**Consultation Response from KC,
Highways Development Management**

2023/91071 Town Cafe, 33, Alder Street, Fartown, Huddersfield, HD1 6LD

Demolition of existing building and erection two storey building with ground floor cafe and first floor office

Date Responded: 5-7-2023.

Rev	Description	Drw	Chk	Date
A	Comments	TM	AM	03/04/2023
PLANNING				
Client: NU CONSTRUCTION.				
Project: TOWN CAFE, 33 ALDER STREET, HD1 4LD				
Drawing: PROPOSED PLANS ELEVATIONS AND SECTIONS.				
Project No:	1772	Drawing No:	02_01A	
Scale: (A1)	1:50	Date:	MAR 23	Checked by: TM AM

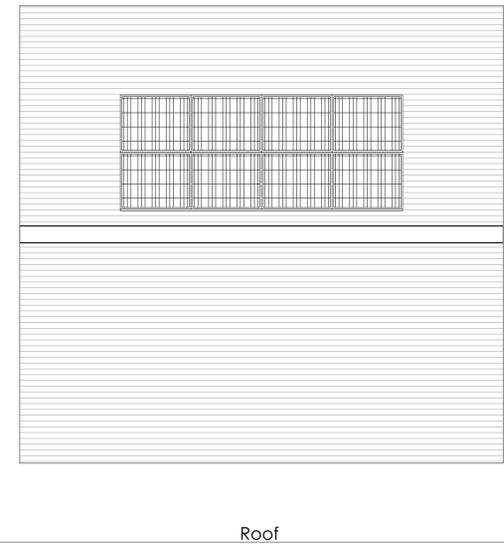
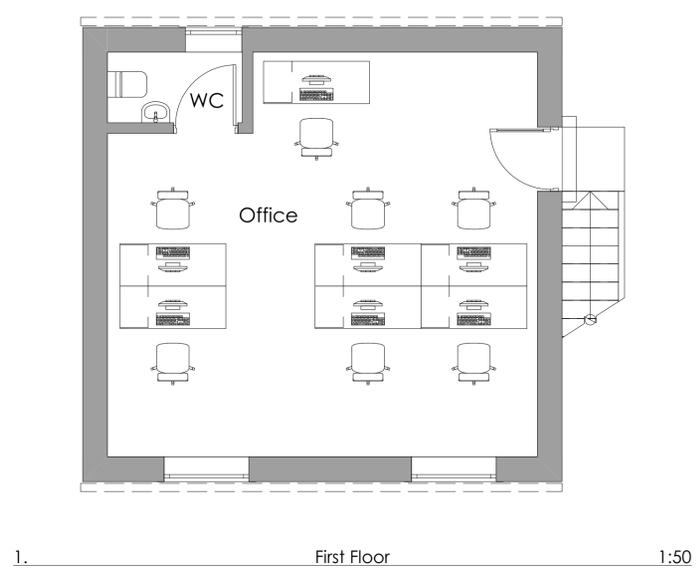
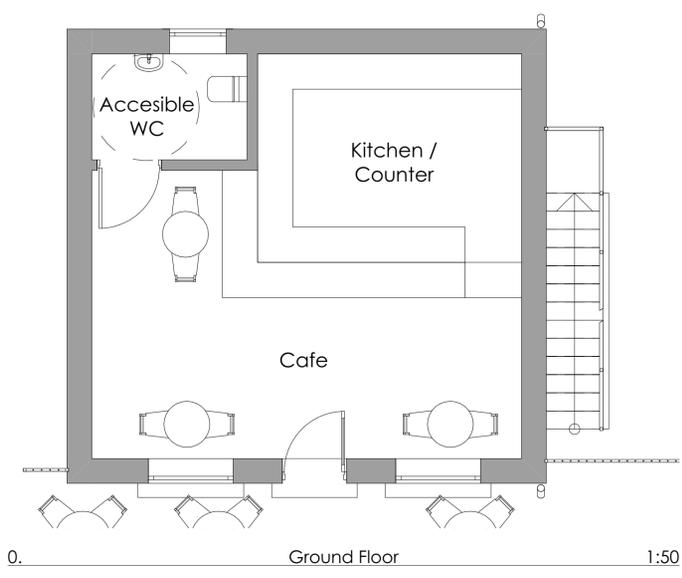
The proposals are for a new building with a small café to the ground floor with an outdoor seating area to the front and an office above. Gated Pedestrian accesses are shown to a rear garden/bin storage area along both sides of the proposed building.

The existing café as no off-street parking facilities and none are proposed by this application.

Bin storage is shown to the rear of the proposed building and there is space in front of the gate to the northern pedestrian access to allow a bin to be left out for collection.

The proposed office is relatively small and subject to the use class being restricted to use class E g (i to iii) Highways Development Management have no objection to these proposals.
